Ref: 3535
12 December 2016

RE: FLOOD IMPACT ASSESMENT – No 84 KIORA RD, MIRANDA

We refer to previous correspondence from Sutherland Council regarding the Flood Impact Assessment carried out for the above development site. Council raised a number of issues that required further clarification in our report however rather than re-issue the report we have addressed the issues below as the matters raised will not impact on the outcome of our initial flood impact assessment report.

Plate 1 – Aerial Photo showing extent of catchment draining to Urunga Lane in green with the site in red

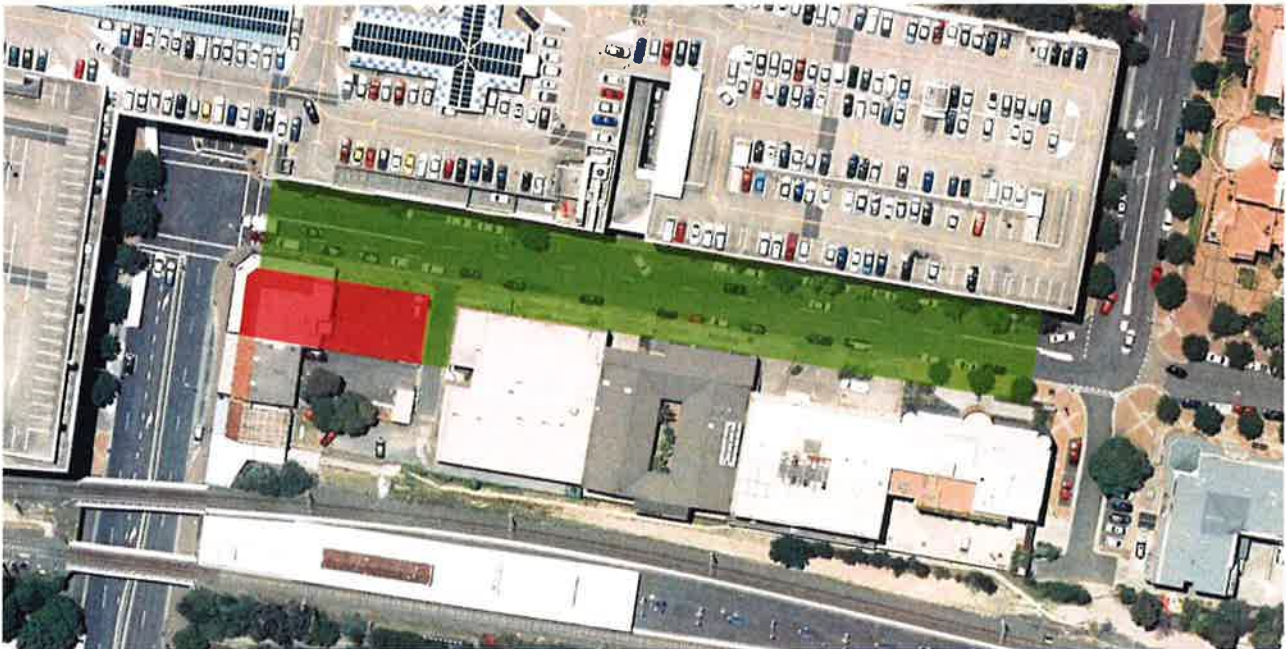
- *Council advised that the analysis did not consider flows from Jackson Ave. They requested that this be done; considered and analyze the spilt of flows into Urunga Pde.*

Based on our site inspections Jackson Ave drains in the opposite direction to the site. The crest in Urunga parade is just west of the intersection with Jackson Ave as depicted by the green shading in the aerial photo. Additional survey was undertaken and the levels confirm that Jackson Ave falls east, north and south of the intersection. Based on this there is no change to the catchment area draining to the site.

Urunga Lane Plan: Plan 02
Geom: Urunga Lane Flow: 100year flow

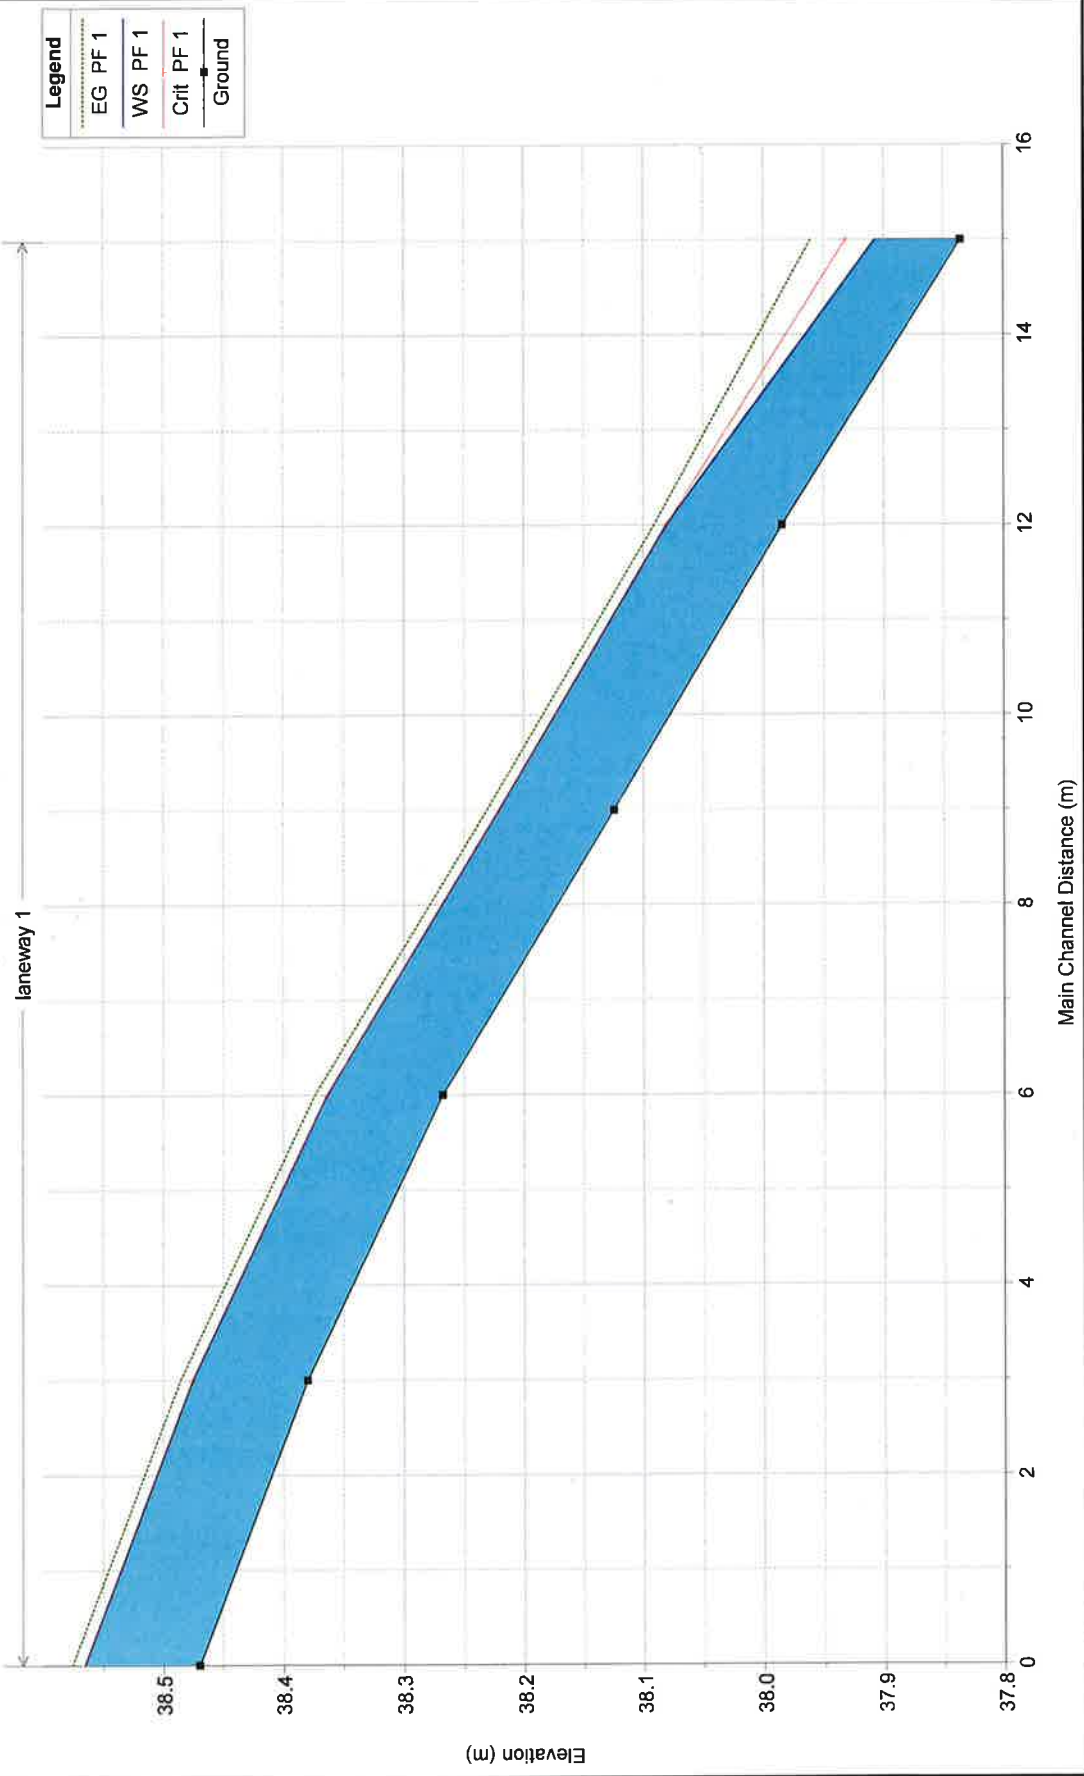
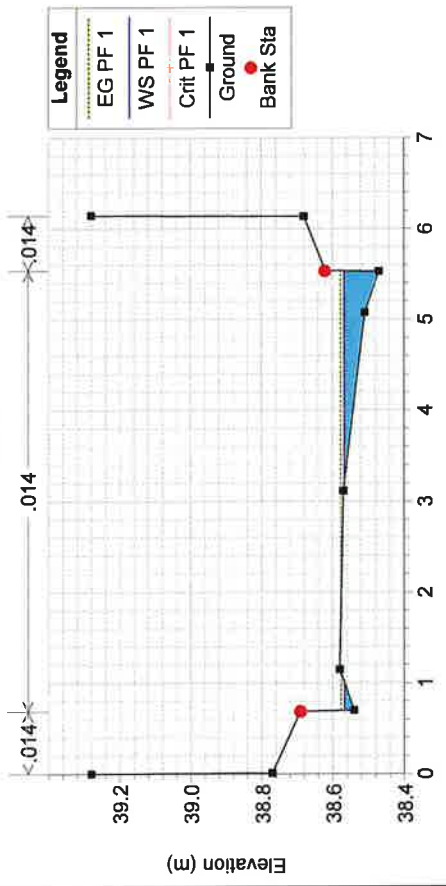
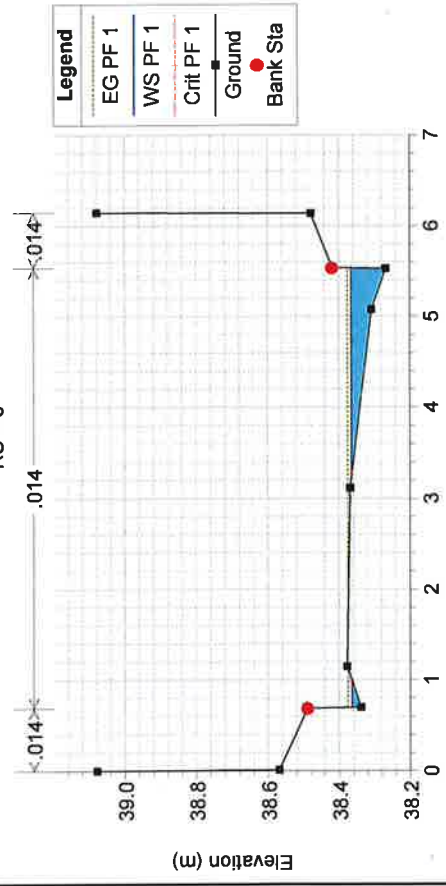
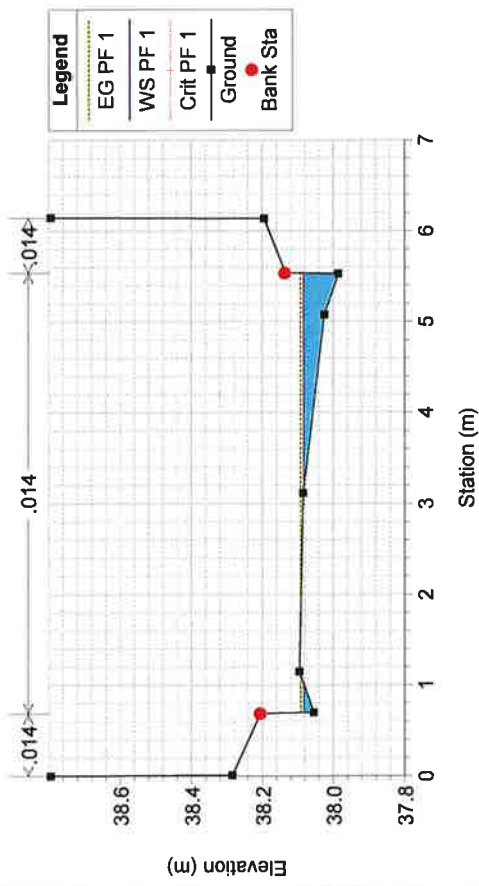
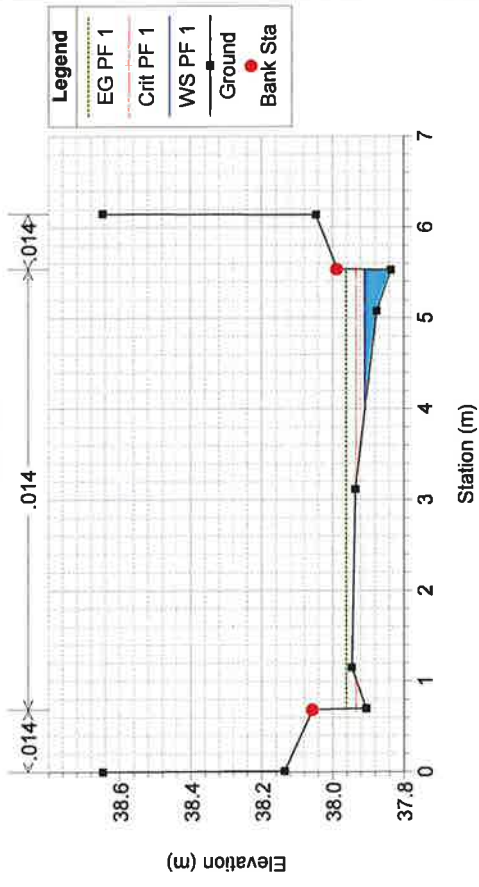
- *Council requires analysis of the flows at the end of Urunga Lane as there is no overland flow path. They want to know what the post development impact is to nuisance flooding / ponding in the lane.*

We have looked at this issue and confirm that the site drains to Kiora Rd and any stormwater entering Urunga Lane is overland flow from the catchment upstream of the site. There is no development works occurring here and therefore there is no change to the flow in Urunga Lane as a result of the proposed development.

The investigation was primarily carried out to determine if the upstream overland flow would flood the site. It was found that the upstream catchment is not very large and therefore the overland flows can be contained within the road carriageway and kerb of Urunga Lane.
